From: [Jeremiah Cromie](#)
To: [Code Enforcement](#); "[joe_509fs.com](#)"
Cc: [lisa6278@hotmail.com](#); [Bill](#); [Samantha Cox](#); [Steph Mifflin](#)
Subject: RE: CE 542 Teanaway Acres, parcel 075235
Date: Friday, March 10, 2023 12:39:54 PM
Attachments: [image001.png](#)

# SITE PLAN

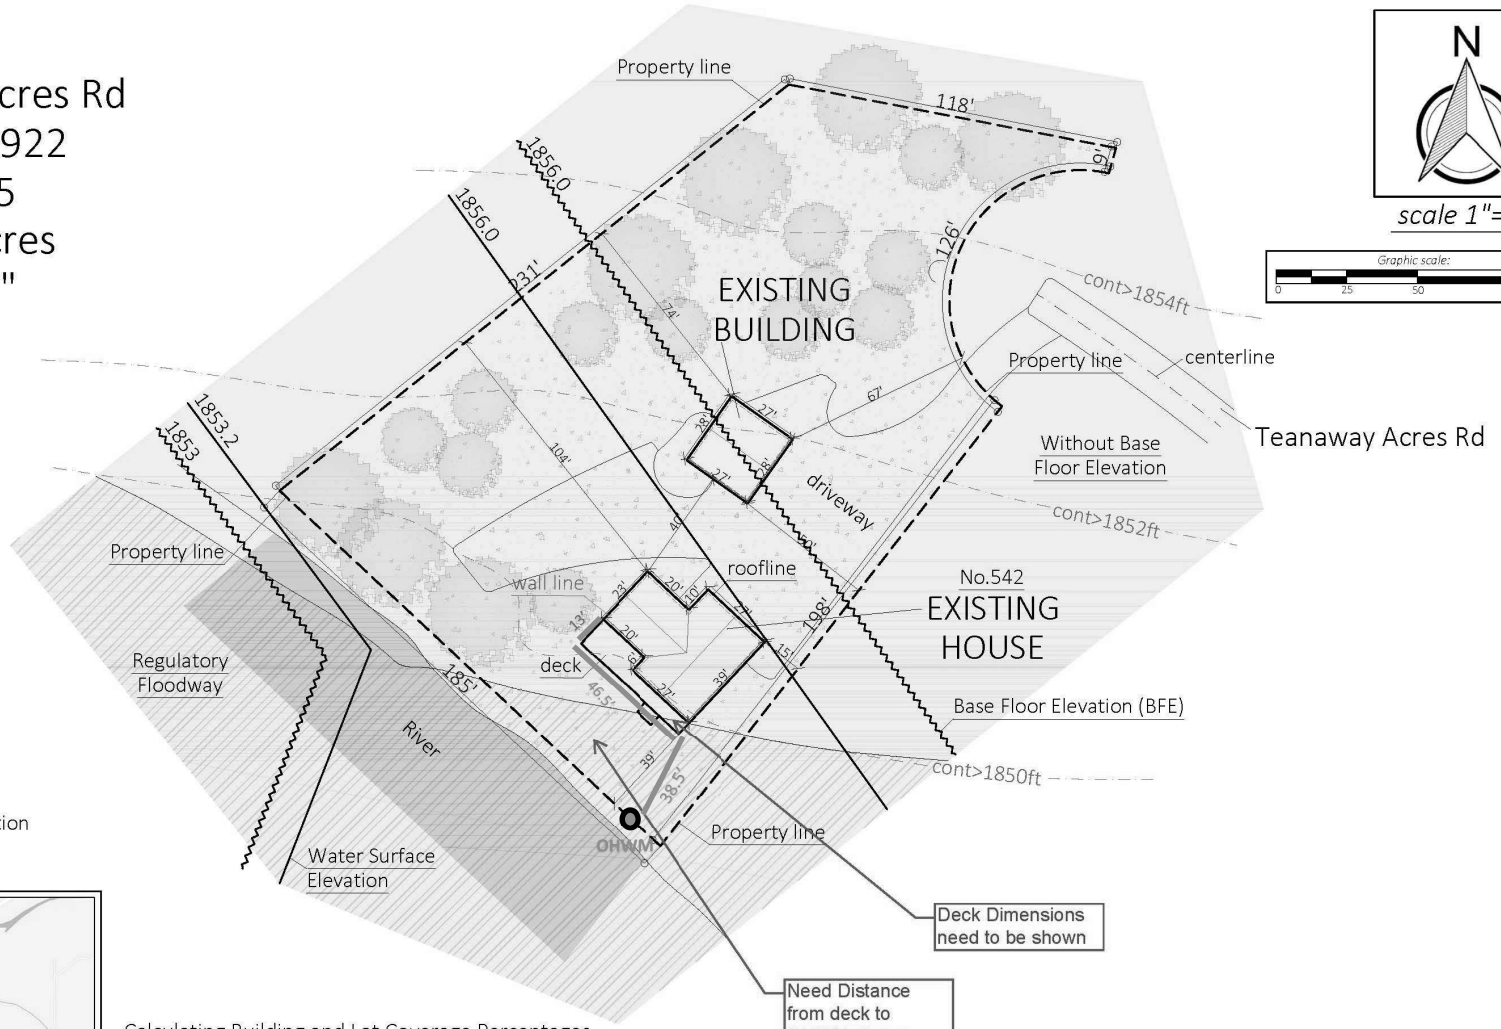
We still have not received an updated site plan with the deck and dimensions of the deck. This will need to be submitted for review so that the County can issue the Shoreline Exemption permit. Thanks.

Hi Joe,
Our schedules look best for Friday at 3 p.m. Please bring the dimensions of the deck, which were left off of the site plan. Thanks.
